Please upload the amended drainage plans attached to this email onto Ocella for **LU/90/20/DOC** for Parcels A2 and B6 at Hampton Park.

Comments;

Paul Cann
Principal Engineer (Drainage)

© This drawing and the building works depicted are the copyright of Banners Gate Ltd and may not be reproduced or amended except by written permission. No liability will be accepted for amendments made by other persons.

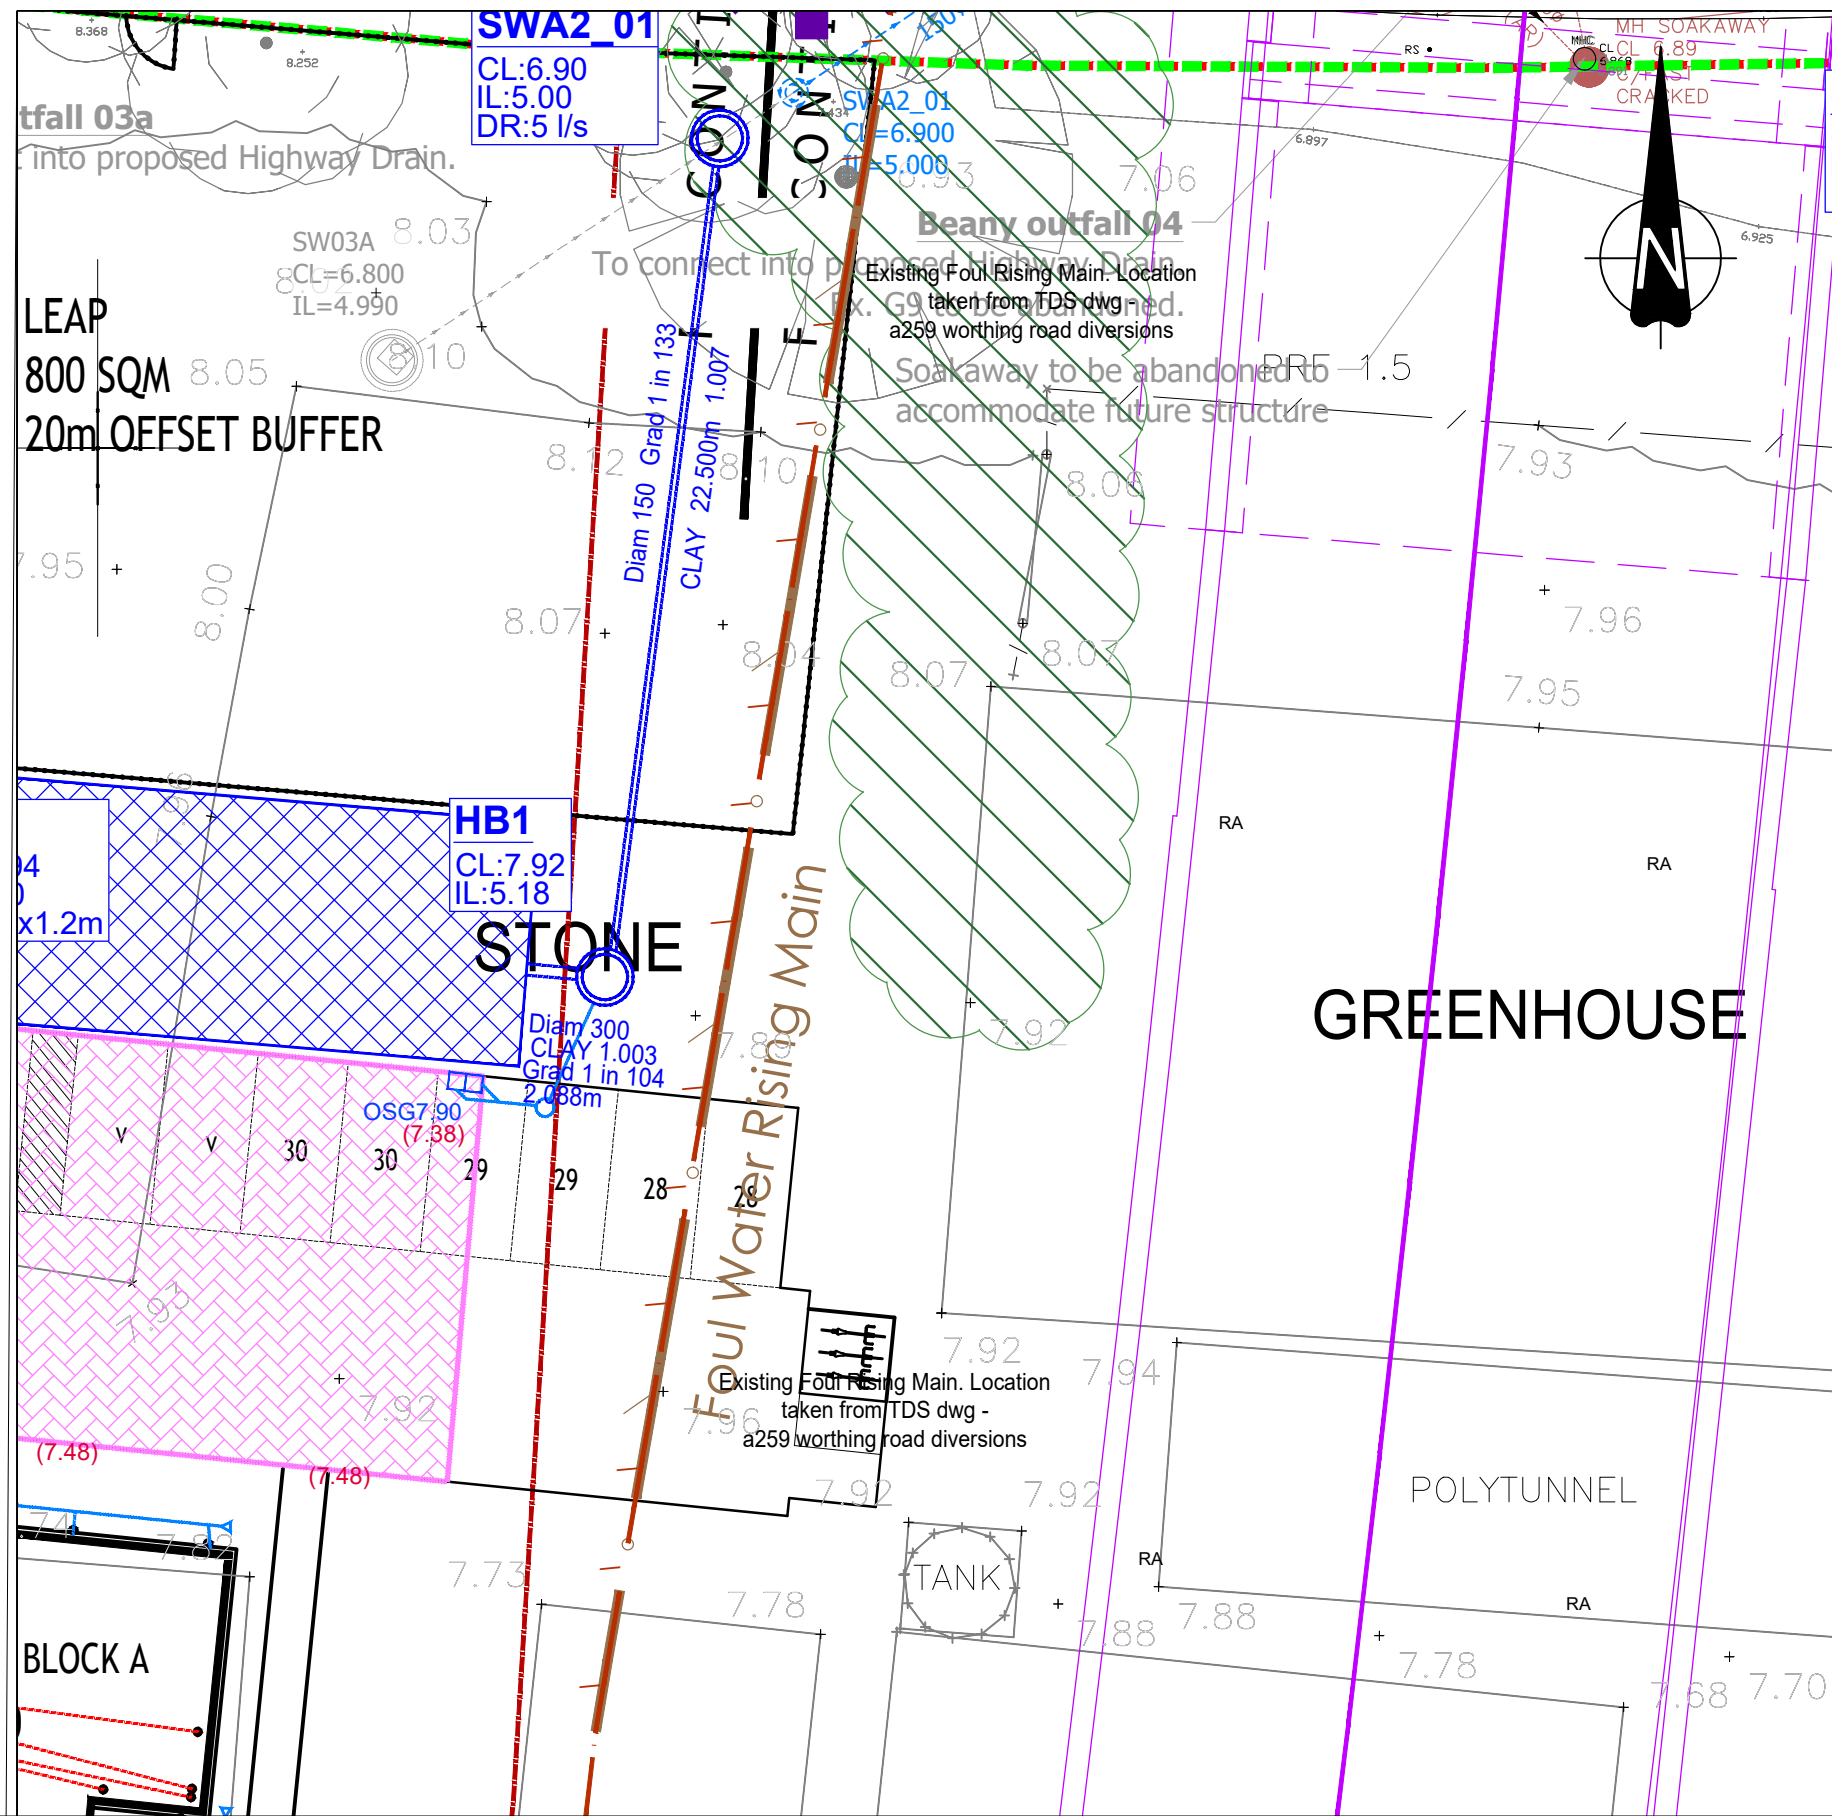
3. Provide channel drain construction details/spec.
4. Hydrobrake chamber HB01 construction detail – connect incoming 150mm connection from permeable paving at soffit to soffit level with 300mm pipe inlet.

6. Both hydrobrake chambers – show base thickness/reinforcement details.
7. Existing manhole SW03A – just upstream of SWA2_01 – what is its purpose? Invert level is lower than the downstream manhole. Please clarify if it is required and adjust as necessary.
